Applicant response to Section 51 advice regarding submitted Application Documents (Issued 25 June 2026)

Planning Inspectorate Application Ref: WA010002

Table 1 Applicant's response to section 51 advice

DRAWING TITLE
ACCESS & PUBLIC RIGHTS OF WAY PLAN
SHEET 3
APFP REGULATION 5(2)(K)

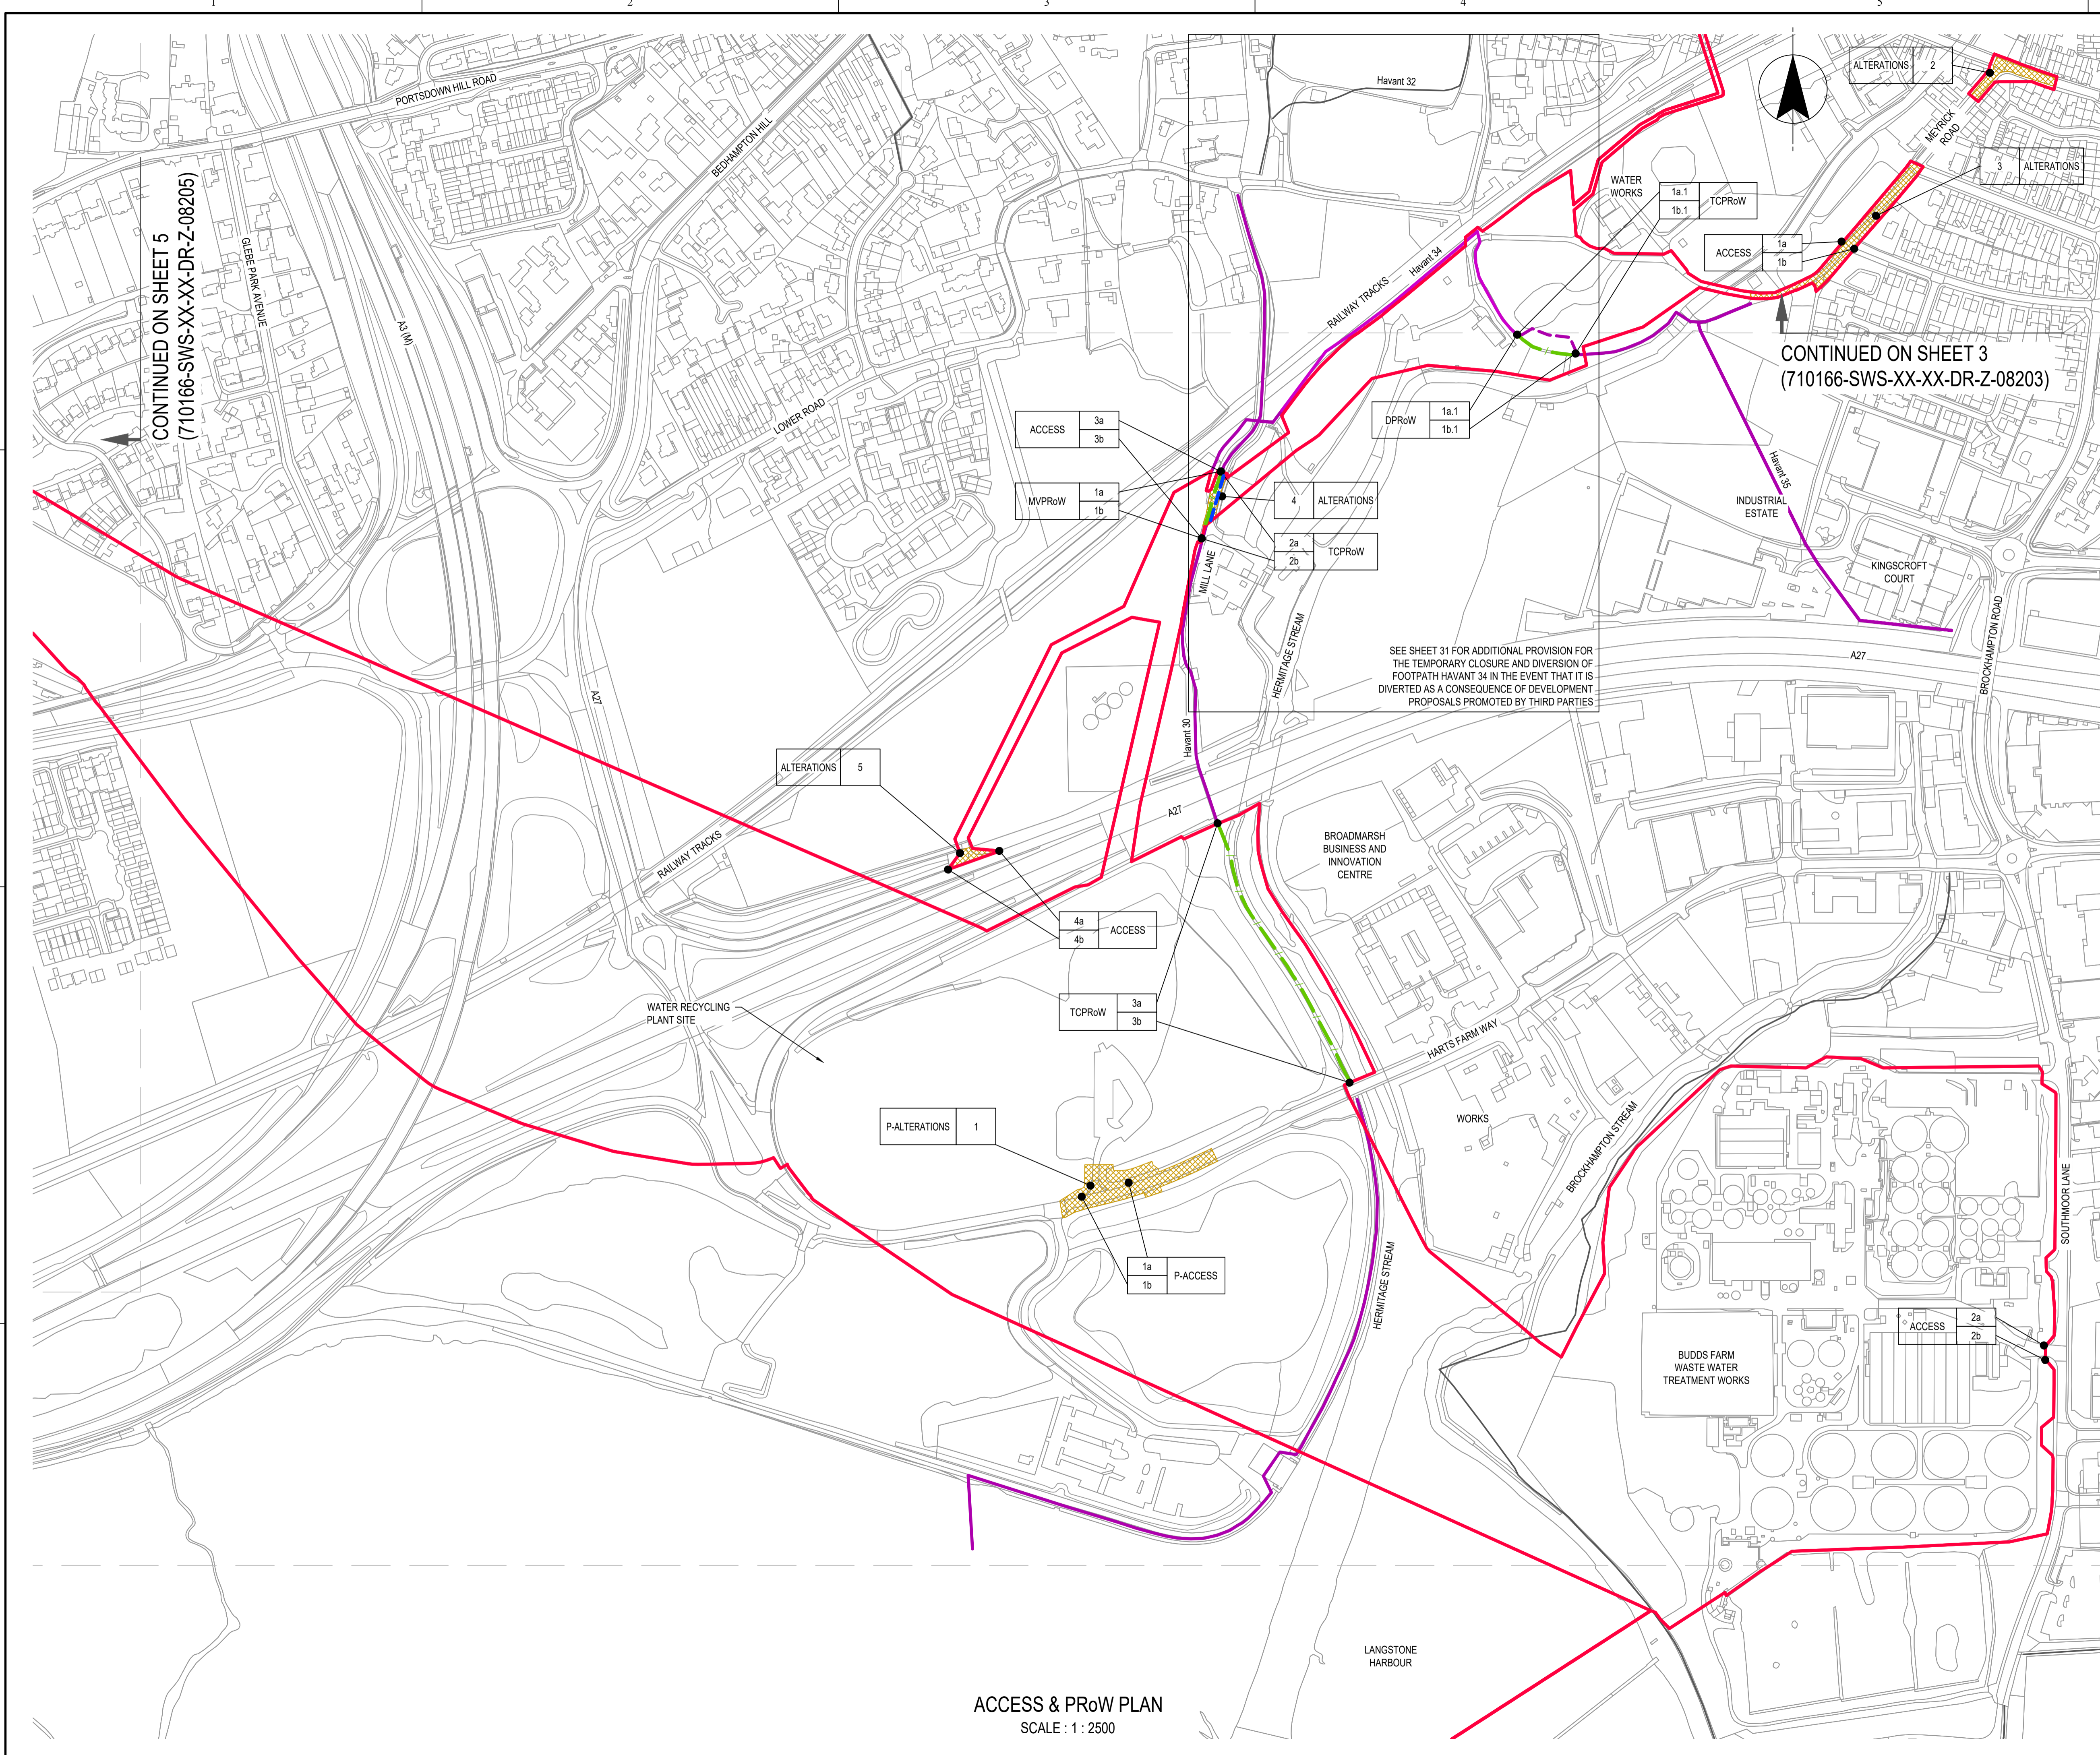
Section 51 advice reference	Summary of section 51 advice	Applicant's response
	On sheets 3 to 8, 10, 13 to 15, 20, 24, 26 and 27 of Works Plans (Docs 2.3) Work No.8, the implementation of highway and access works, as shown in the Access and Rights of Way Plans (Docs 2.4), are listed in the legend, appear on the plan but are not labelled. Sheet 2 of ES Vol III - ES Figure 1.1 Location of the Proposed Development and Order Limits (Doc 6.3) labels Construction compound C-1 and WRP Construction compound. Sheet 4 of Works Plans – 2 of 3 documents (Doc 2.3) shows Work no.6 Construction Compounds covering areas that correspond with ES Figure 1.1 except for Construction Compound C-1 and WRP Construction compound; which on the Works Plan appear only as Work no.5 Above Ground Plant and Work no.1 Water Recycling Plant. Construction compound K-6 also does not appear on its corresponding sheet in the Works Plans; that area is solely marked as Work no.5D Break Pressure Tank K.	numbered works and each Work No. includes various components including construction compounds (where relevant) as set out in Schedule 1 of the Draft Development Consent Order (APP-023). For example, Work No.1 (WRP site) provides for the permanent WRP infrastructure and the temporary construction compound works. Similarly, Work No. 5 (AGP sites) provides for the permanent AGP infrastructure, temporary construction compound works and any access works.
